21 December 2021

**St Aloysius College - Rozelle Campus (SSD-27208140)
Response to Submissions**

Attachment A

Car Park Mark Up

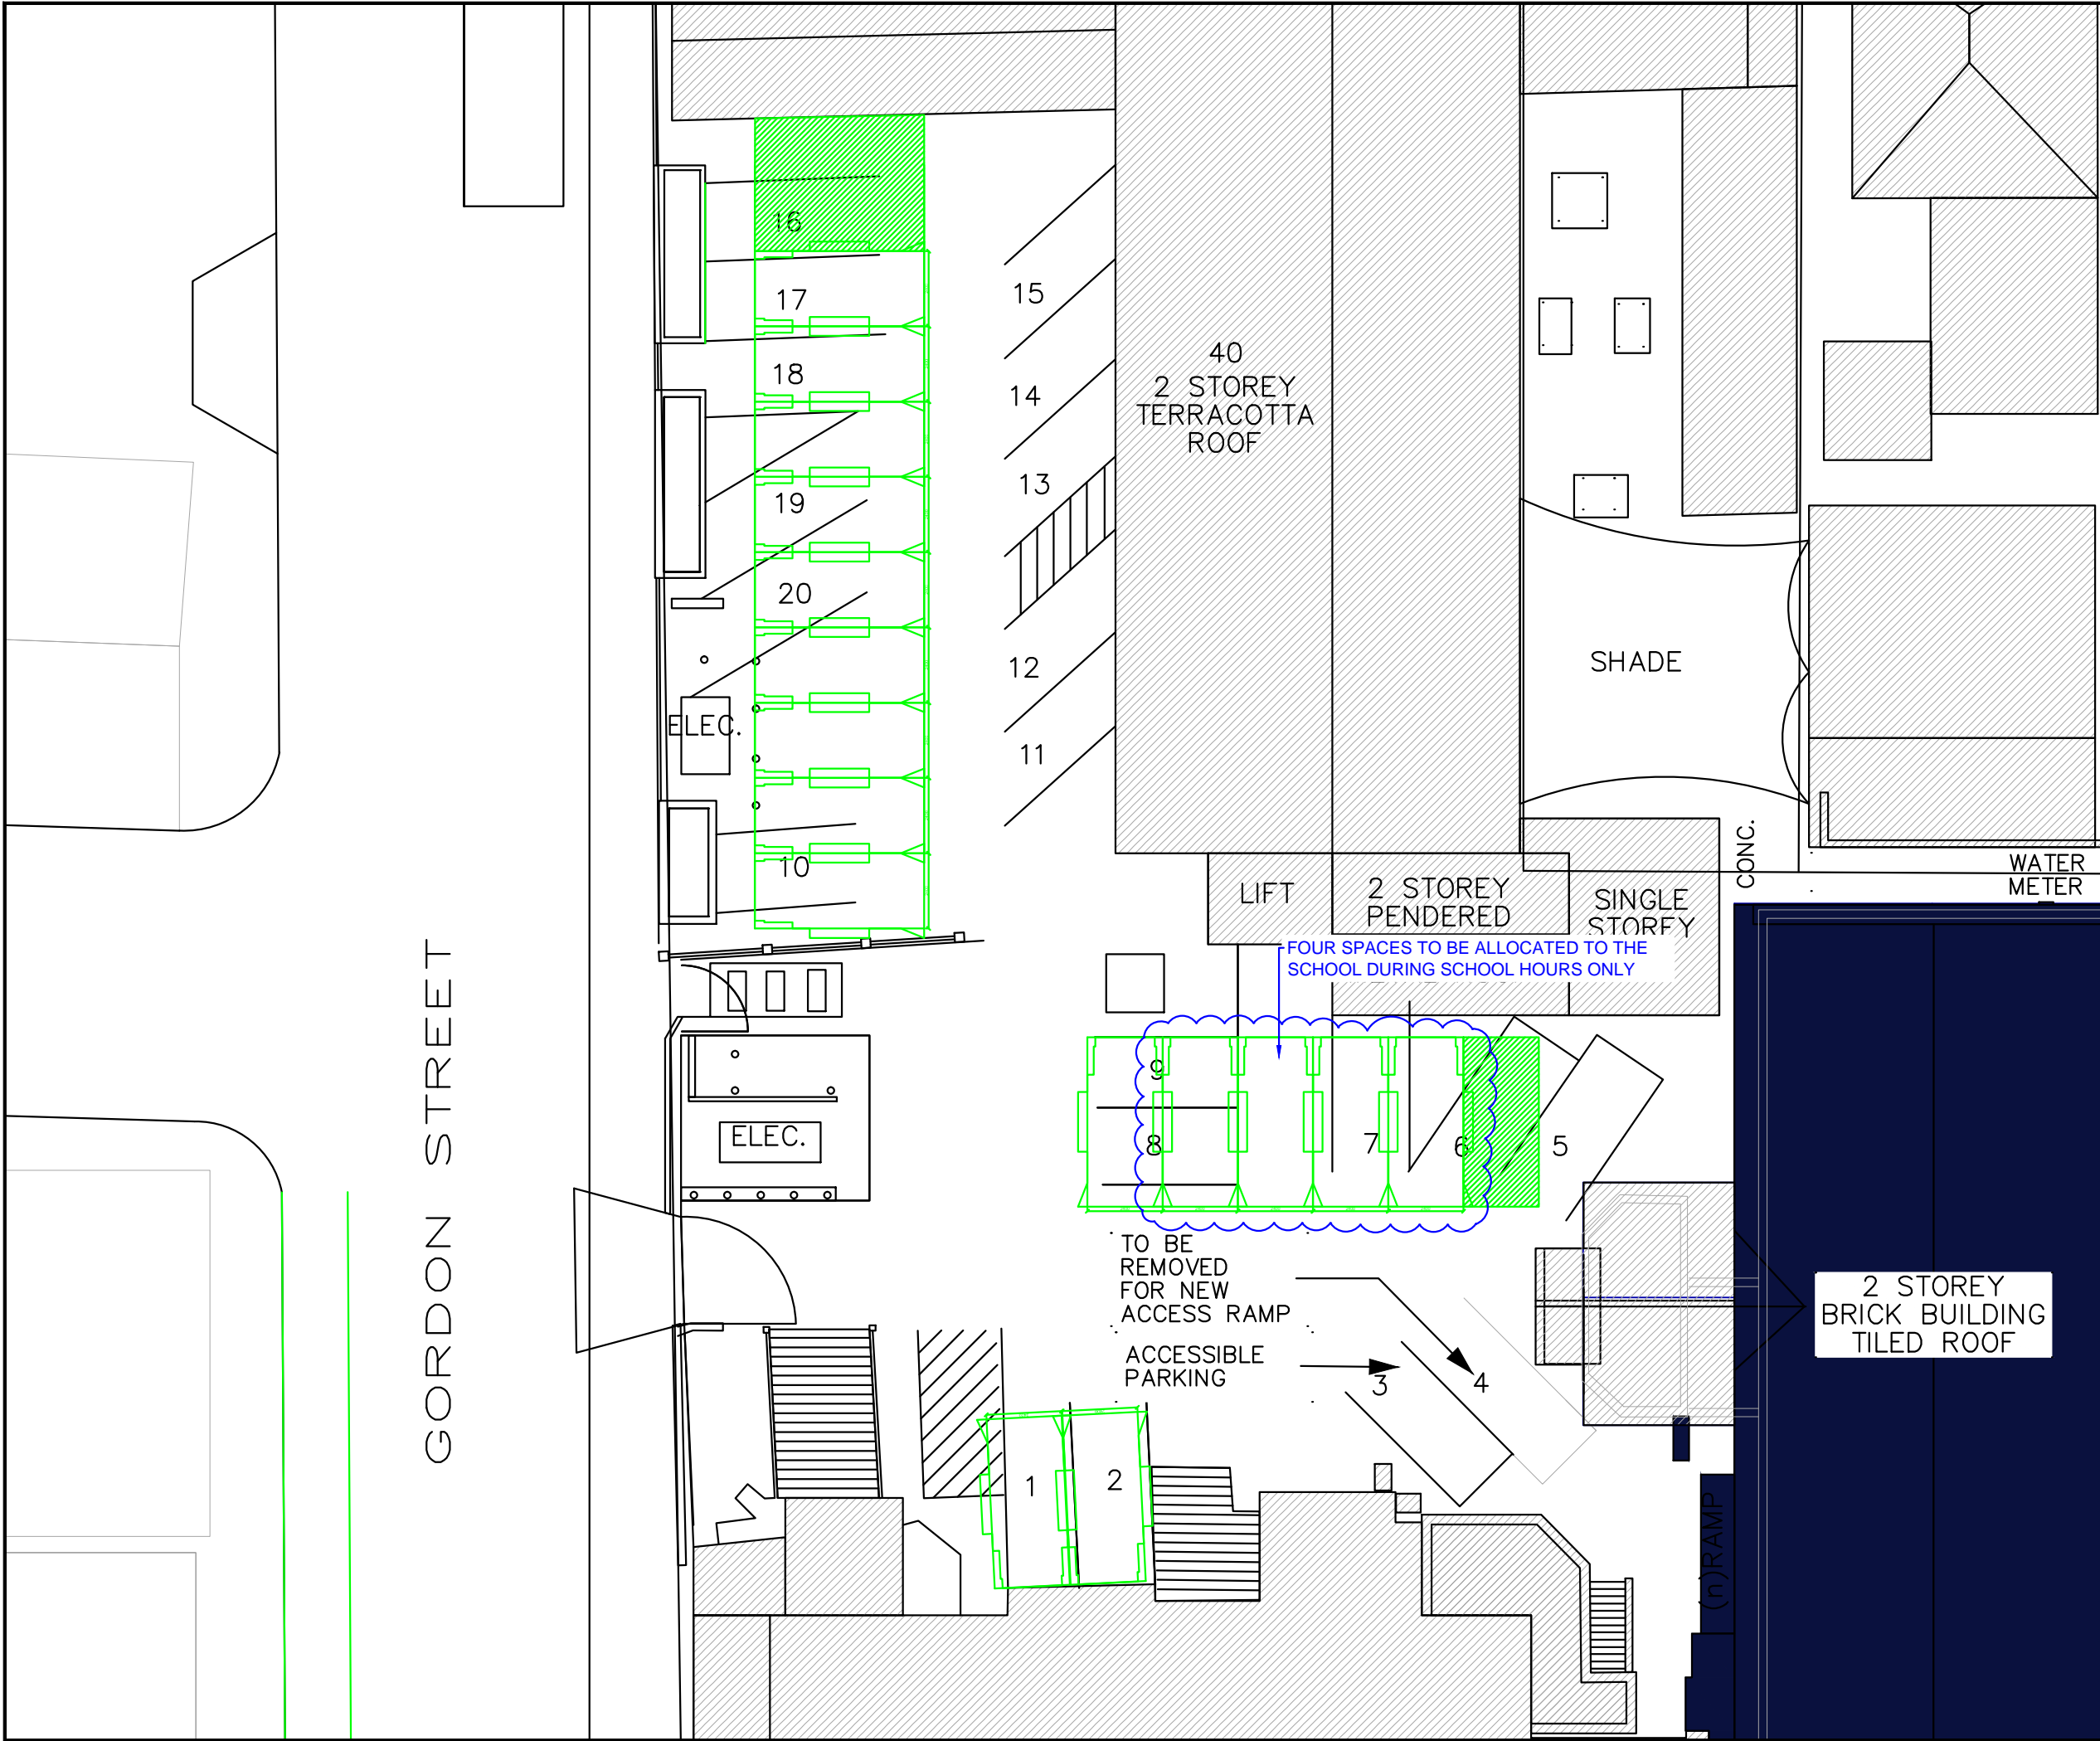
- The EIS does not include any details of the use of the ground floor of 2A-2B Gordon Street, nor does it indicate how many parking spaces would be required to cater for the other uses within the site including the church use. The TAIA also does not assess how the overall car parking area would operate with the concurrent uses on the site and whether the available car parking spaces are sufficient to cater for all of the uses within the site. Consequently, the Department requests that you submit a parking layout plan and mark the nominated parking spaces for the proposed development as well as all of the other uses within the site.
